**MAJOR PROJECT ASSESSMENT:
MIXED USE DEVELOPMENT
7-9 GIBBONS STREET, REDFERN
(MP 08_0112)**

Director-General's
Environmental Assessment Report
Section 75I of the
Environmental Planning and Assessment Act 1979
October 2010

DRAWING:
GIBBONS STREET
(WEST) ELEVATION
DRAWING No.:
DA - 1301
ISSUE:
C
JOB No.:
5414

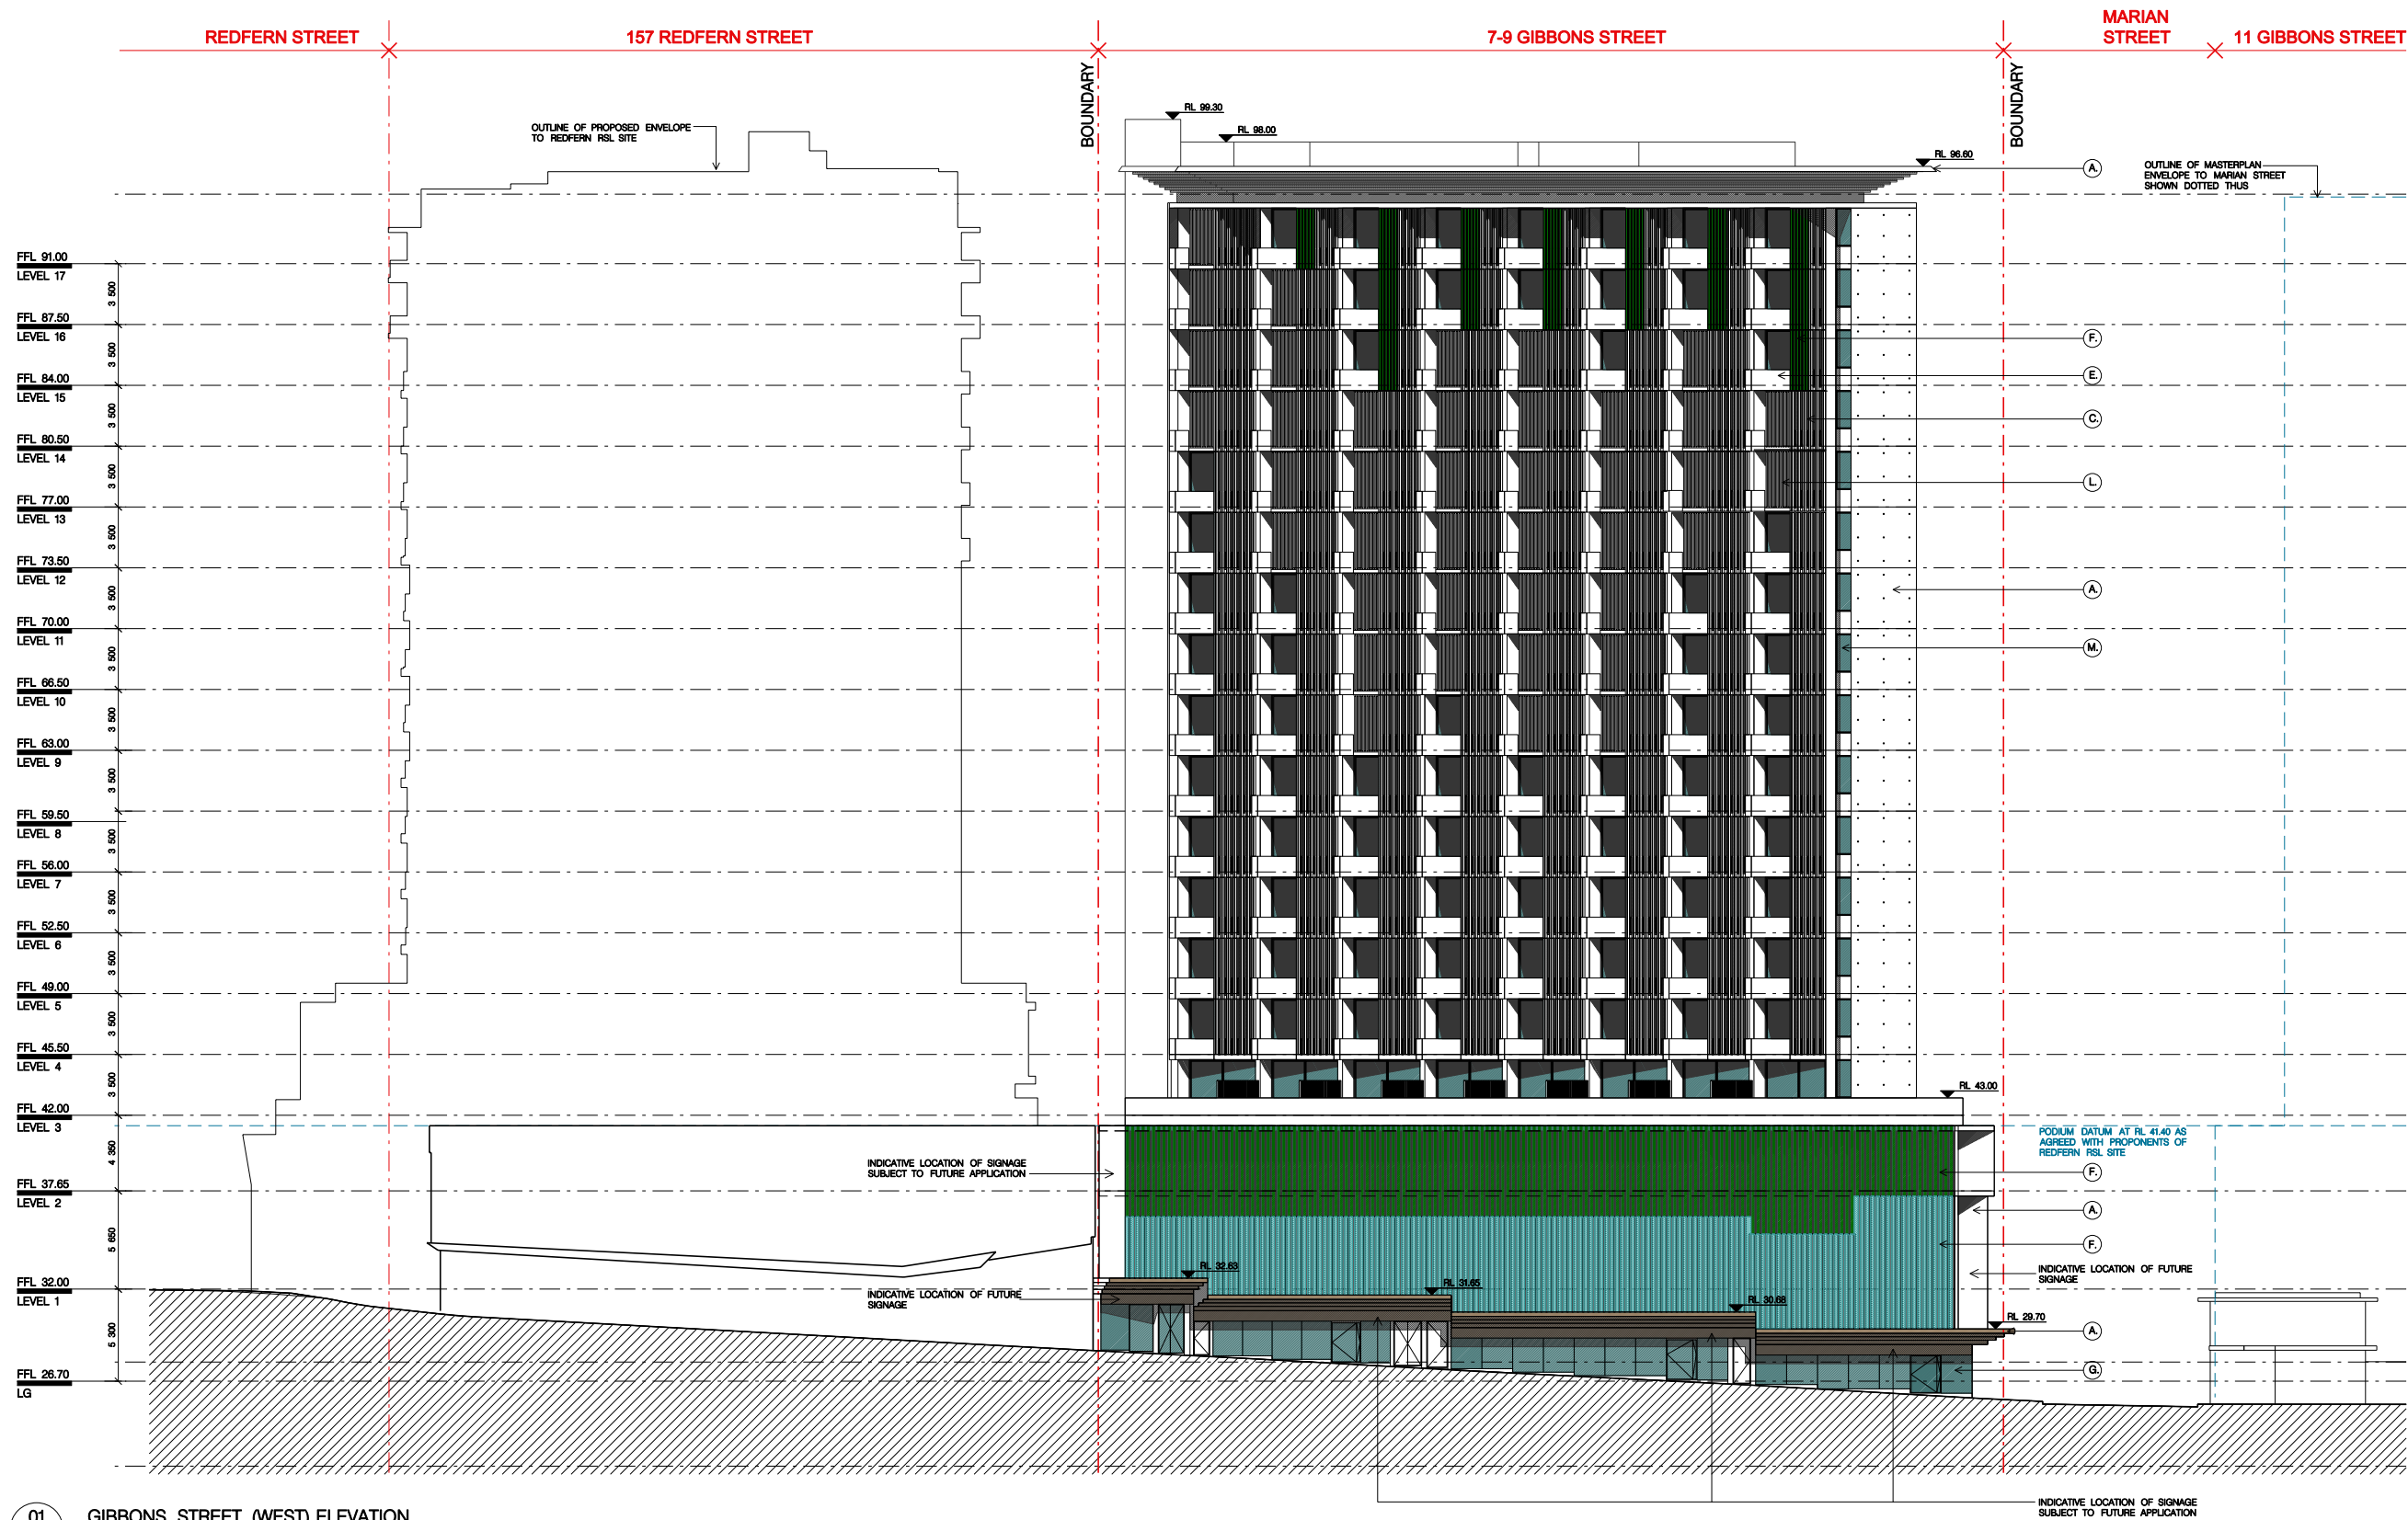
The Marian Street, Gibbons Street and William Lane podium elevations were raised as an issue by the Council and the Redfern Waterloo Authority. The Gibbons Street elevation at the podium level will be treated with glass fins separated by an awning expressed in an off-form concrete finish. The ground level retail tenancies will be provided with full height glazing. The Marian Street podium elevation will be similar in treatment with glass fins and additional precast concrete finishes.
